Dinuka McKenzie - M5

From: "Pollard" <pollard3@tpg.com.au>  
To: <plan\_comment@planning.nsw.gov.au>  
Date: 5/18/2011 5:23 PM  
Subject: M5

**From:** Alf Najera Electronic Alliance <alf@eaa.net.au>  
**To:** <plan\_comment@planning.nsw.gov.au>  
**Date:** 5/19/2011 8:14 AM  
**Subject:** Noise barriers

In regards to the Georges River bridge in Casula:

Figure 8.7 Location of existing and proposed new or augmented noise walls

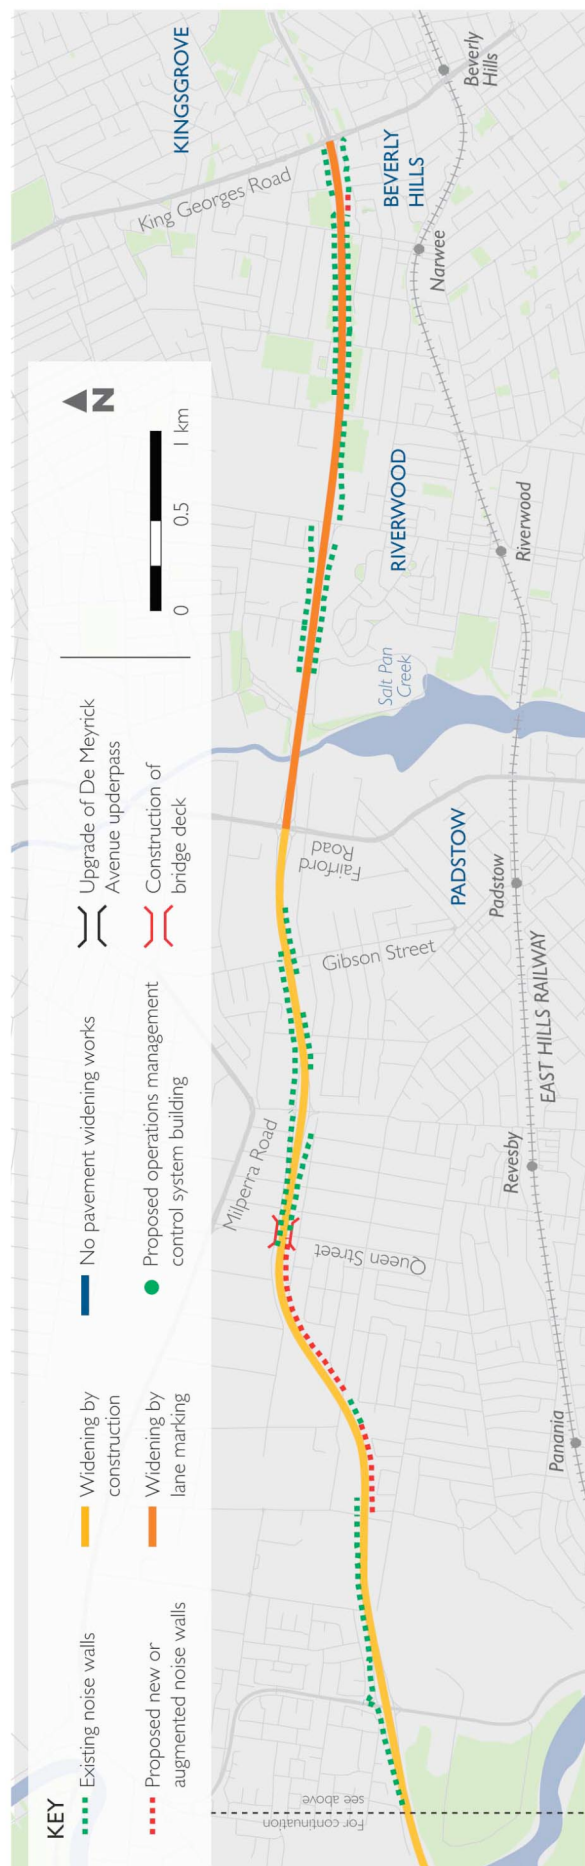
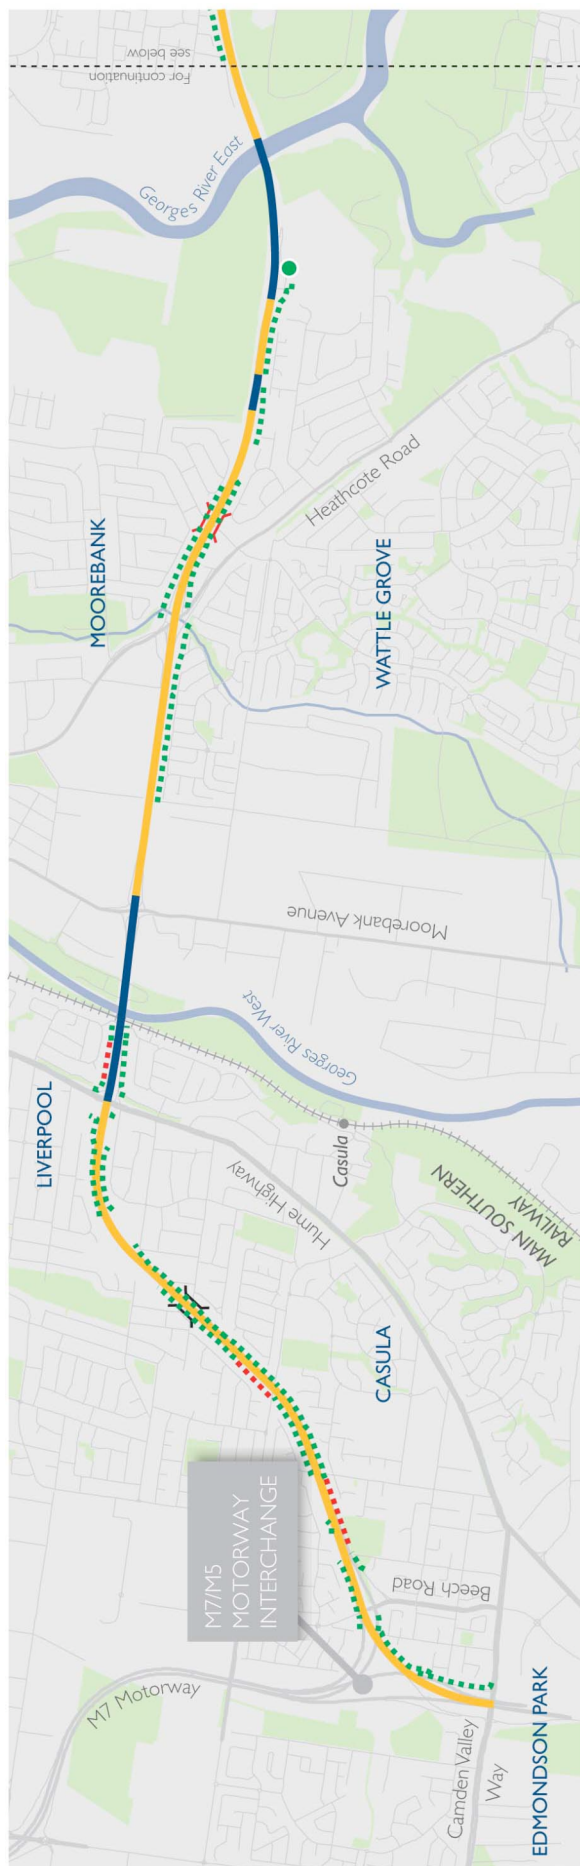
>From your Planning Web site we have notice one very important issue, that you are proposing NOT to installed noise barriers on the the George River Bridge, while in your original proposal the community was informed that noise barriers on this bridge were part of the M5 improvement project. Your department must understand that the noise cause by the traffic on this bridge does already exceed the so called safe level of noise, while at the same time the bridge is surrounded by houses from the Casula Links state. There are a group of houses that are no more than 150Meters away from the bridge and the noise level from there property is unbearable at most time. At peak hour traffic it is hard to sleep from our property that is a good 400Meters away. While on the high side of the state, residents as far as 700 meter away are having problems with the noise cause by the traffic on the bridge, and the traffic level will only get worse with time, so it makes absolutely no sense what so ever to delete the proposed noise barriers from this bridge.

We can not understand why the Georges River bridge is the only section of the M5 to remain without noise barriers considering the amount of people being affected. The noise barriers on the bridge are not required to be very high, a 1.5 to 2 meter high barrier along the bridge would be more than sufficient to drastically cut the noise currently affecting the local residents.
